Hi Maya, further to our conversation of the 28th October, I write as requested to reply to some of the statements made in Lancashire Highway Association's response of 24th October 2024 to our planning application number 3/2024/0802.

Swept Path of Light Van Arriving
(4 Point Manoeuvre)
Scale 1 / 250 @ A3

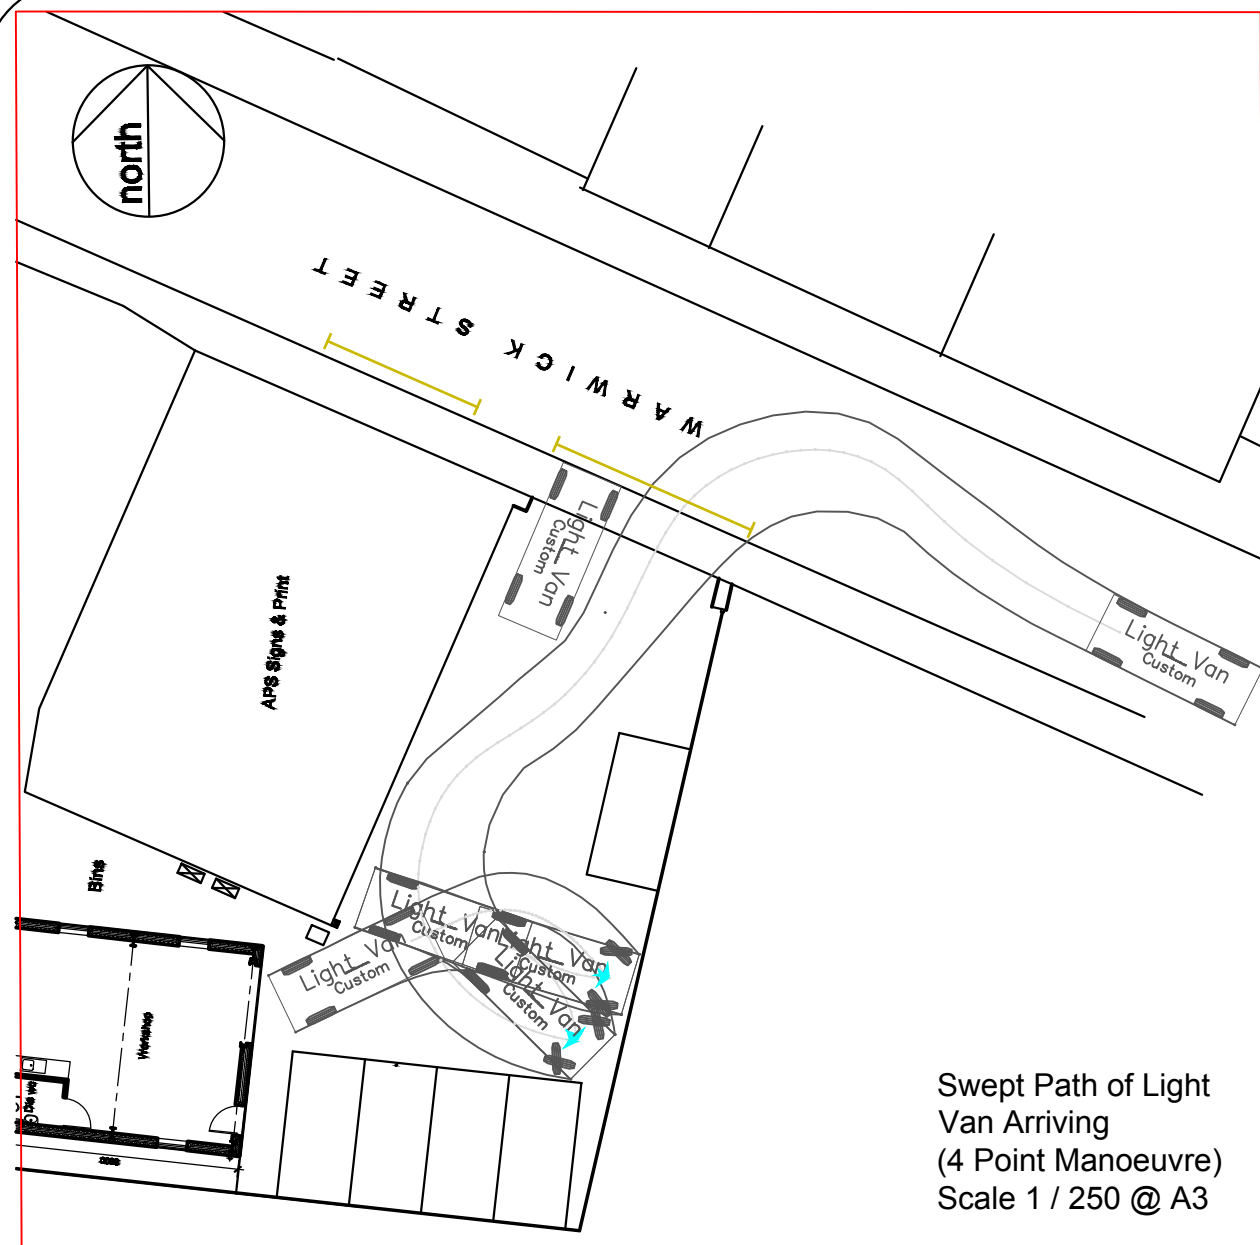
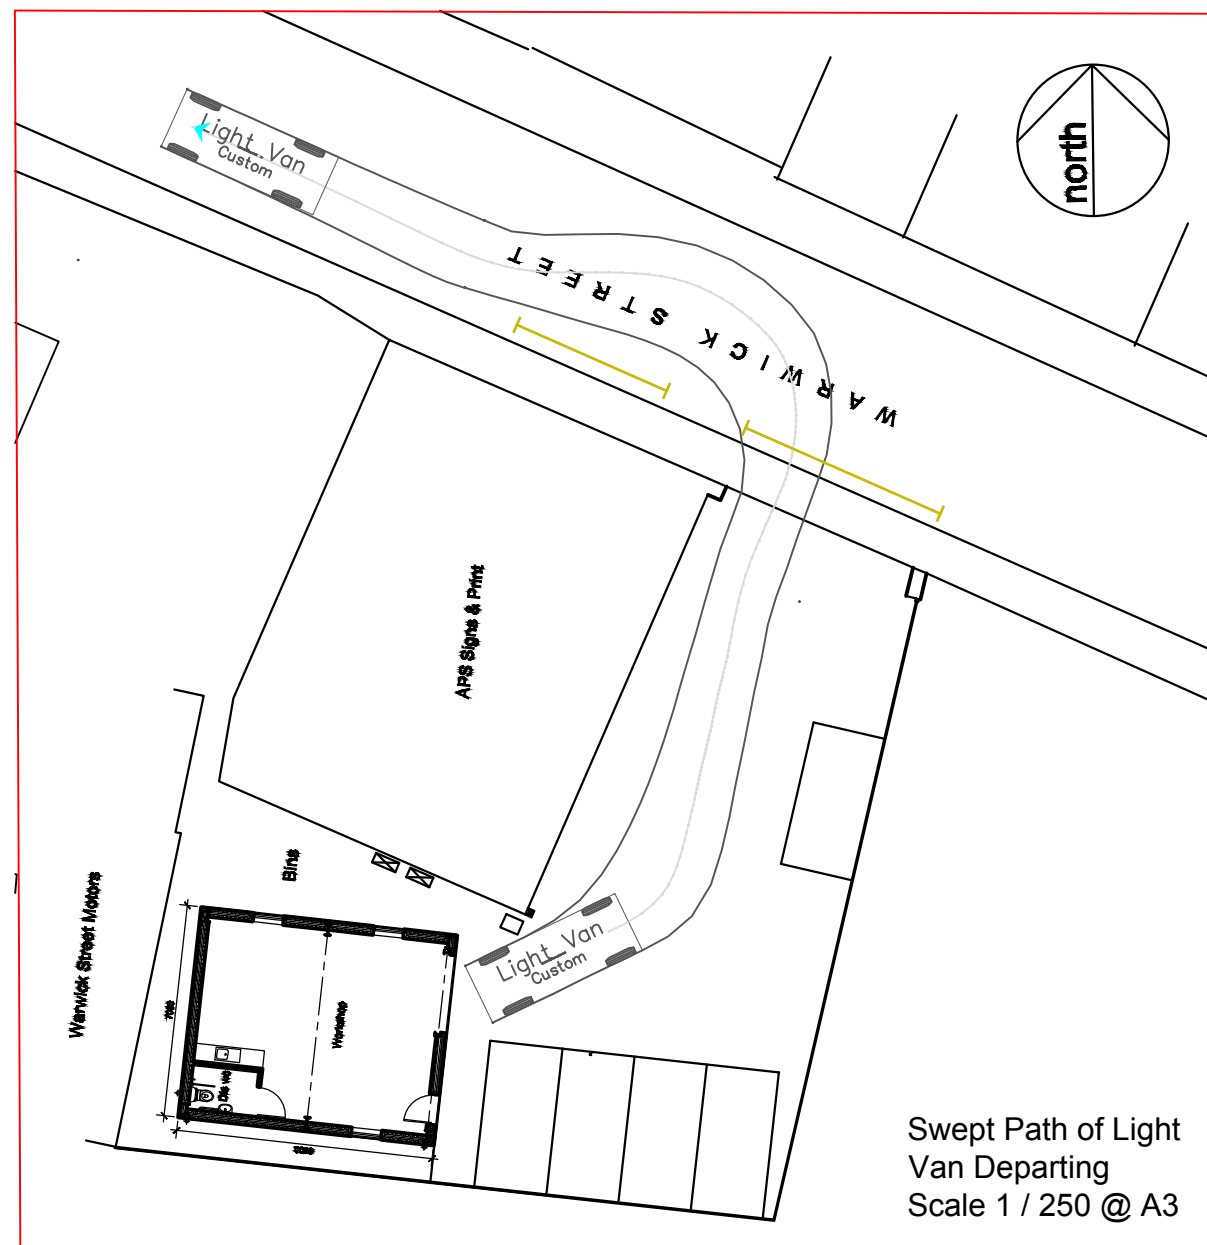
LHA simply dismissing the parking review showing the manoeuvre undertaken by a light van to enter and exit the site in a forward gear on document 240901/01 as not working in practice. LHA's response has been written by someone who has not visited the site and is unaware of the details. After speaking to CTS Traffic they stand by their findings.

Job No:	240901	Drawn By:	J.L.
Date:	Sep 2024	Checked By:	J.L.
Scale:	1 / 250 @ A3	Drawing No:	240901/01

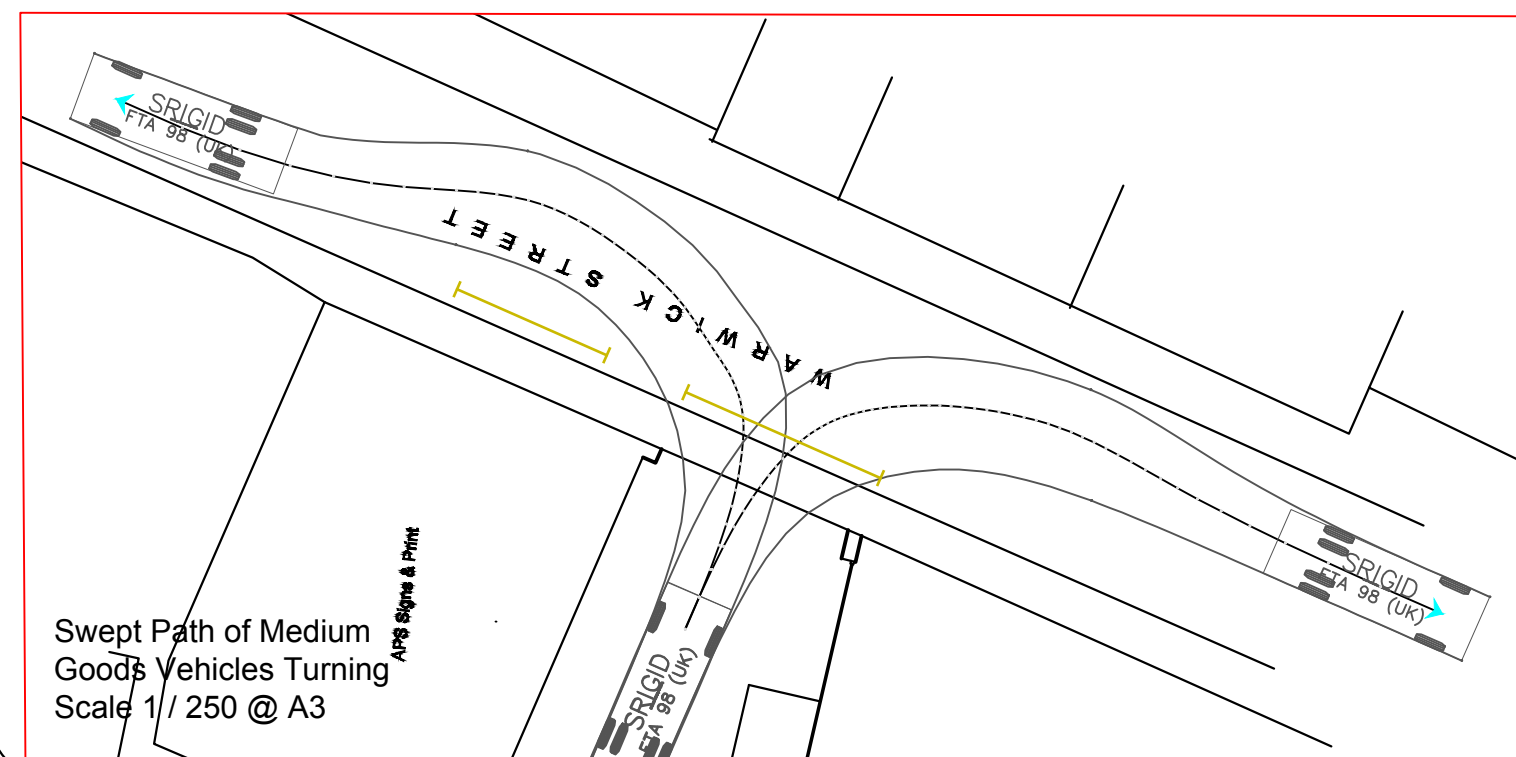
Page 3 paragraph 4 questions the safety and number of the parking spaces provided on the plan; this can simply be rectified by moving all spaces away from the boundary fence by 0.6m

Swept Path of Medium Goods Vehicles Turning
Scale 1 / 250 @ A3

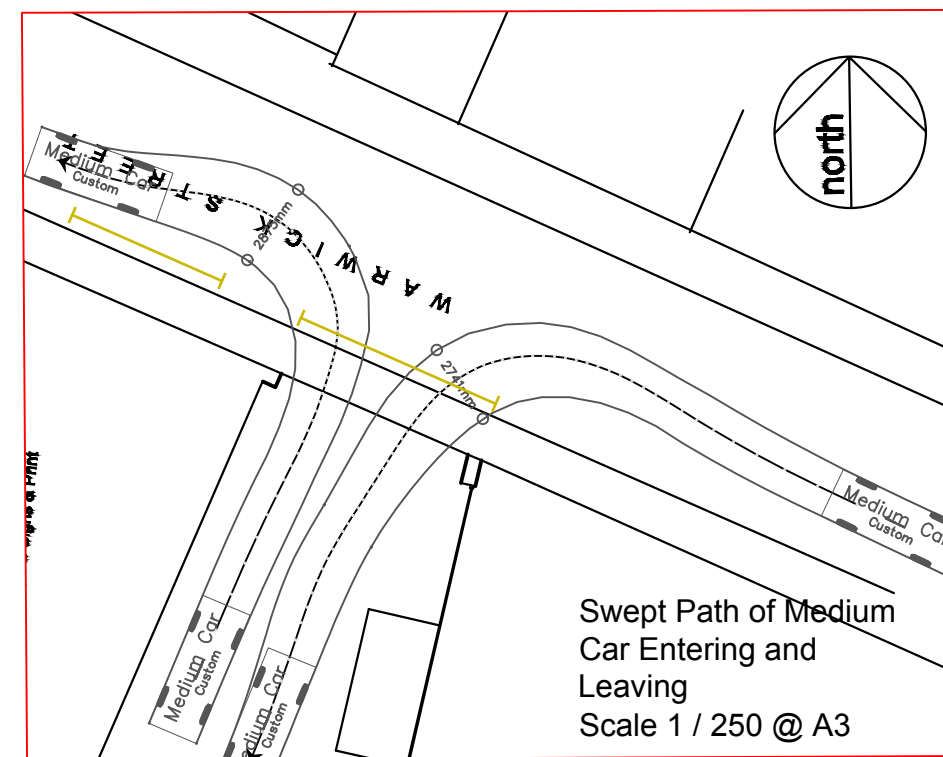
Page 2 Paragraph 5, drawing 240901/01 shows a medium goods vehicle REVERSING into the site and exiting the site in a forward gear, not a medium goods vehicle entering the site in a forward gear.
